Reference: Engineering Services
244 Hazelwood Rd.
Lillington, NC
Project No.: 2401-020986

As requested, the undersigned representative of Tyndall Engineering and Design, PA (TE&D) has provided the following engineering services:

- 1) 3RD party footing projection repair located along the rear foundation wall.

FOUNDATION PLAN
Braxton

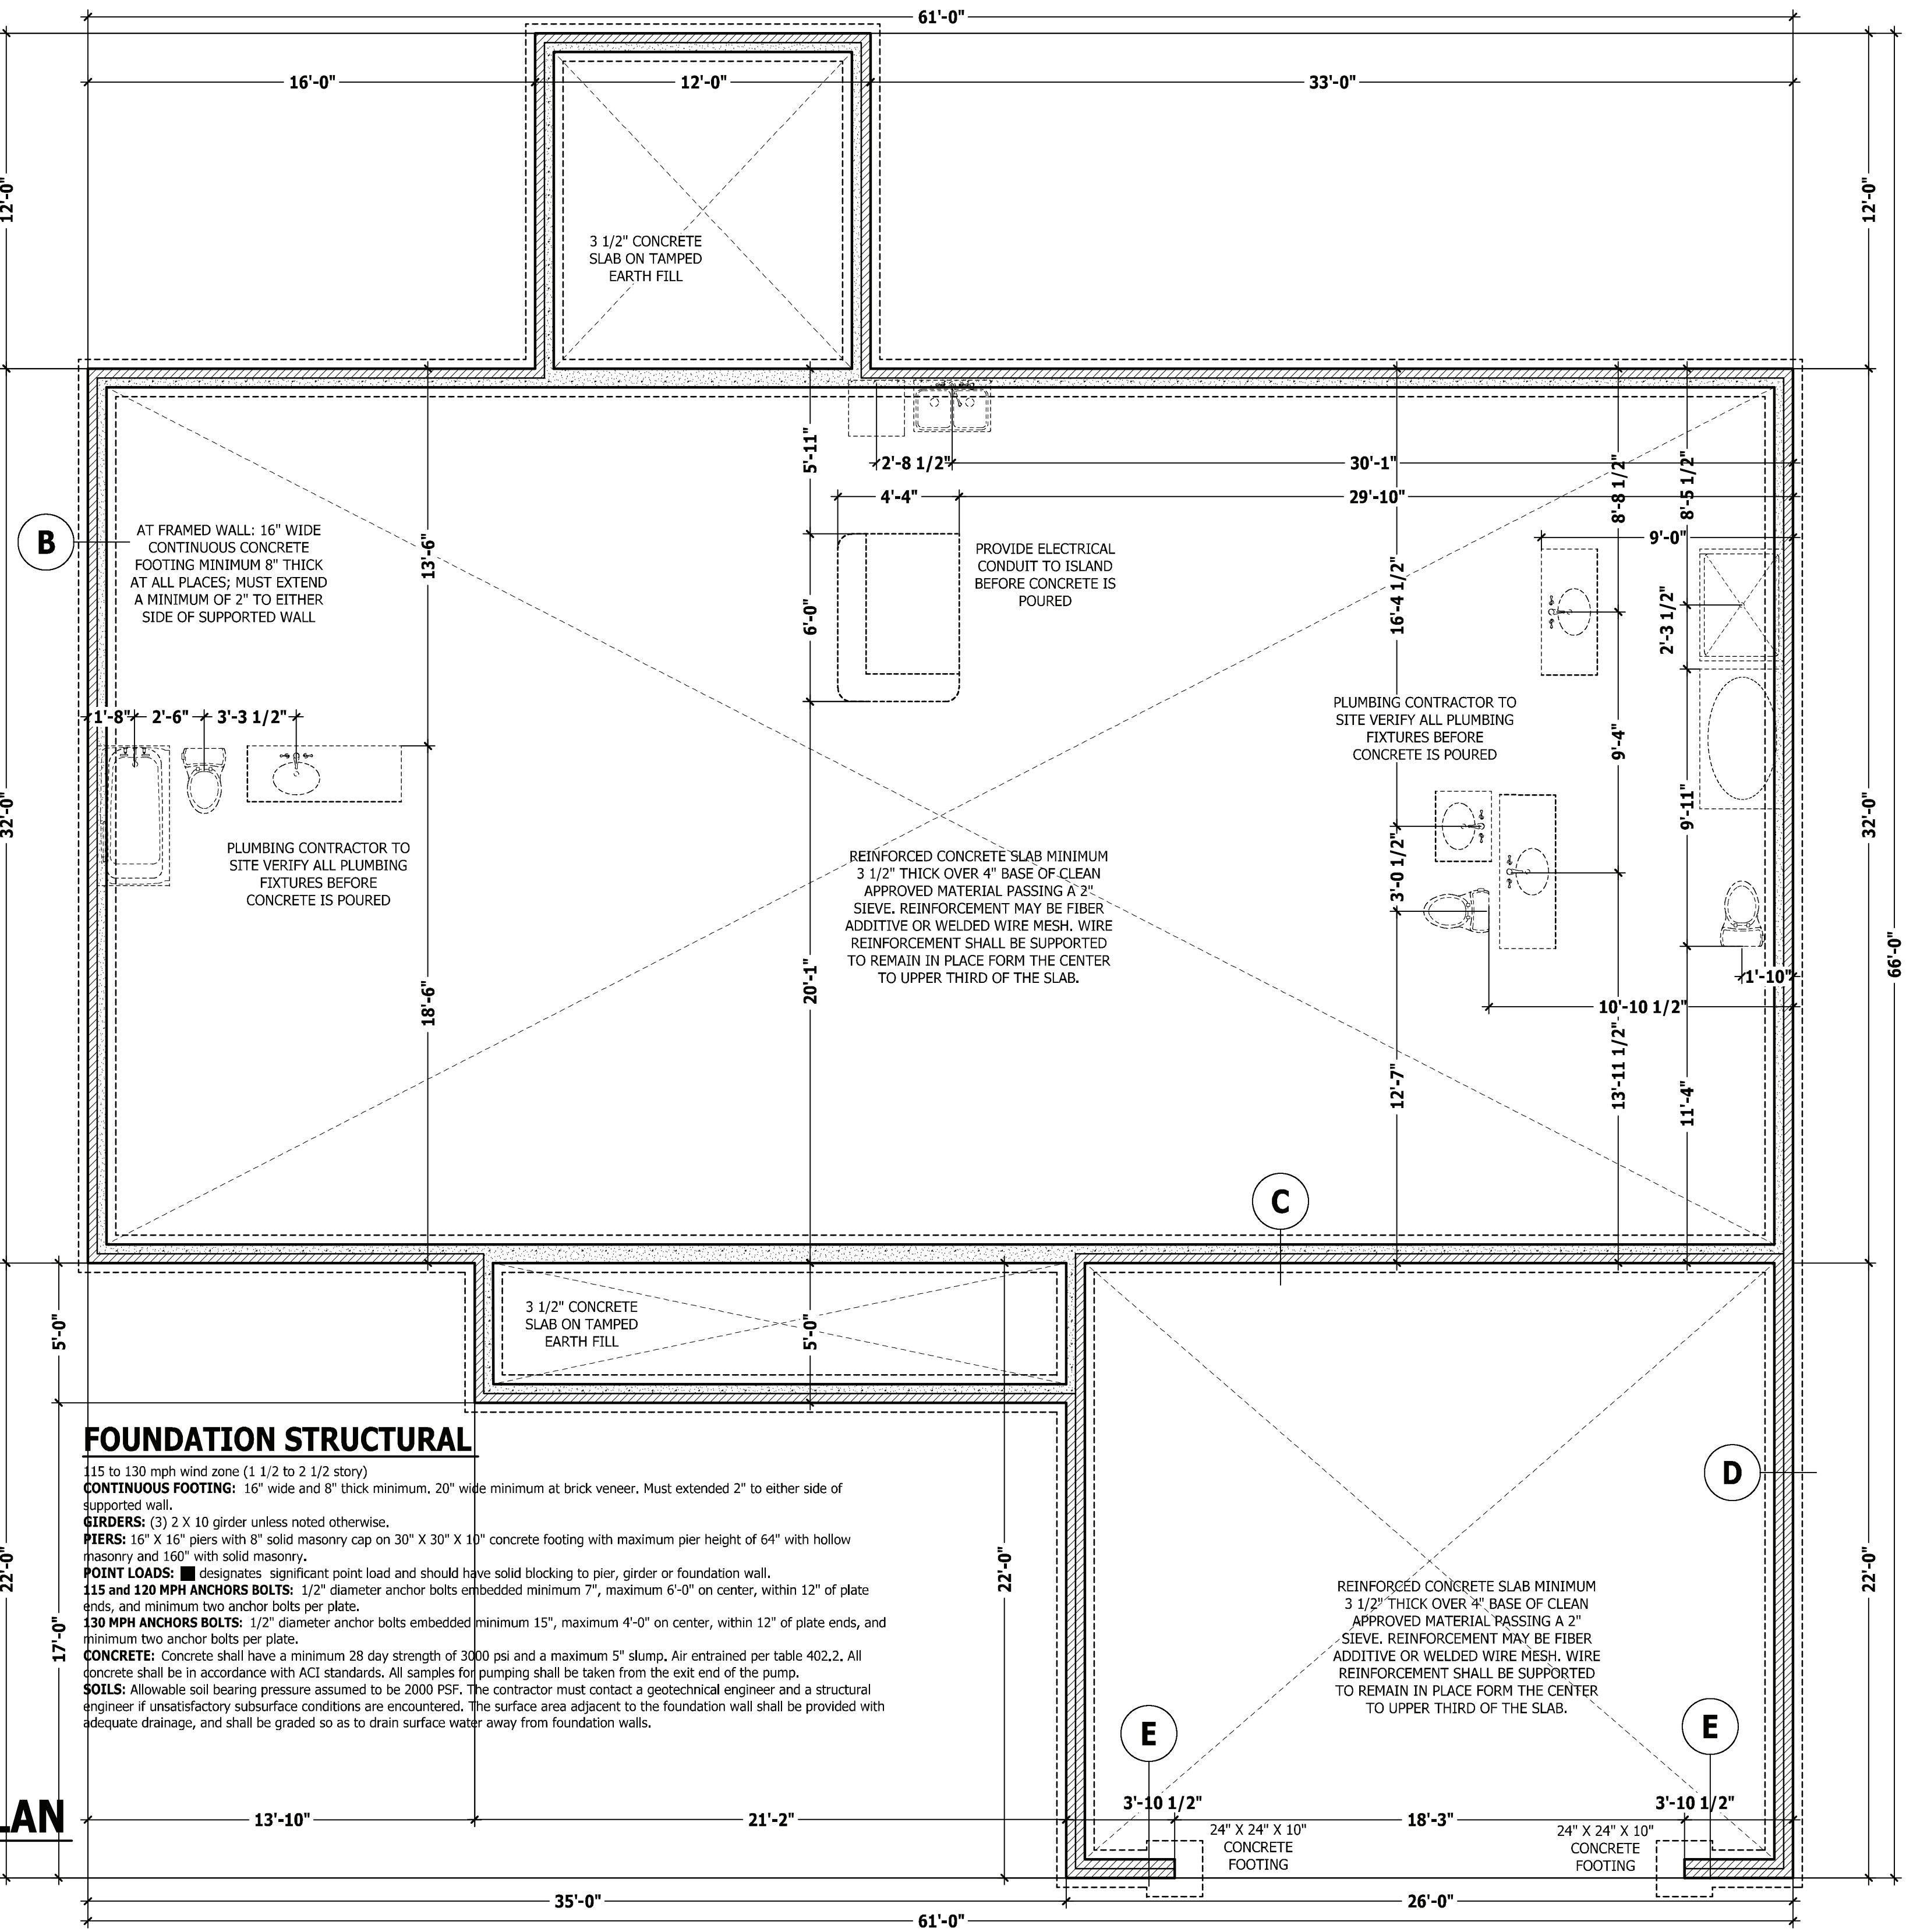
- 1) The existing footing projection repairs consisted of the addition of an 8” #4 rebar dowel embedded 4” into the existing concrete footing. The new rebar dowels are located within 1 foot from the corners and at 2 feet on center in the field. The existing repairs are adequate to support the anticipated loading conditions.
